Re: **Overhanging Sill Plate**
Location: Lot 3A Brairwood Bluff - 62 Gray Pine Way Sanford, NC
JDS Project No.: RDU2508855
Date of Inspection: 08/26/2025

A representative of JDS Consulting arrived on site to observe the issues reported to us by the client, which are presented, along with our recommendations, in this report.

3 TYPICAL SLAB ON GRADE GARAGE PERIMETER FOOTING

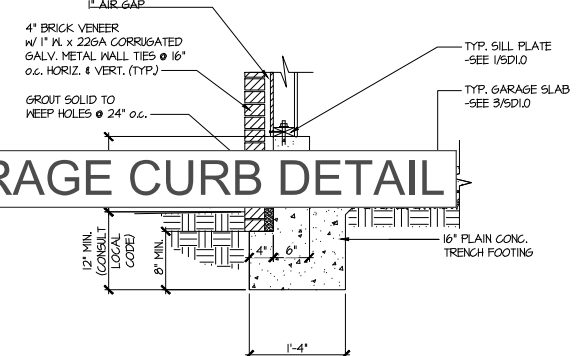
The sill plate of the rear wall of the garage overhangs the face of the monolithic slab foundation by 1-1/8" at the right side and 3/4" at the left side.

Based on our onsite observations and review, install a treated 2x cut to fit tightly between the overhanging sill plate and the top of the garage slab. Attach the treated 2x support to the face of the concrete slab foundation with (1) 1/2" x 6" Simpson Titen HD screw at 12" o.c. placed 2" from the top of the house slab.
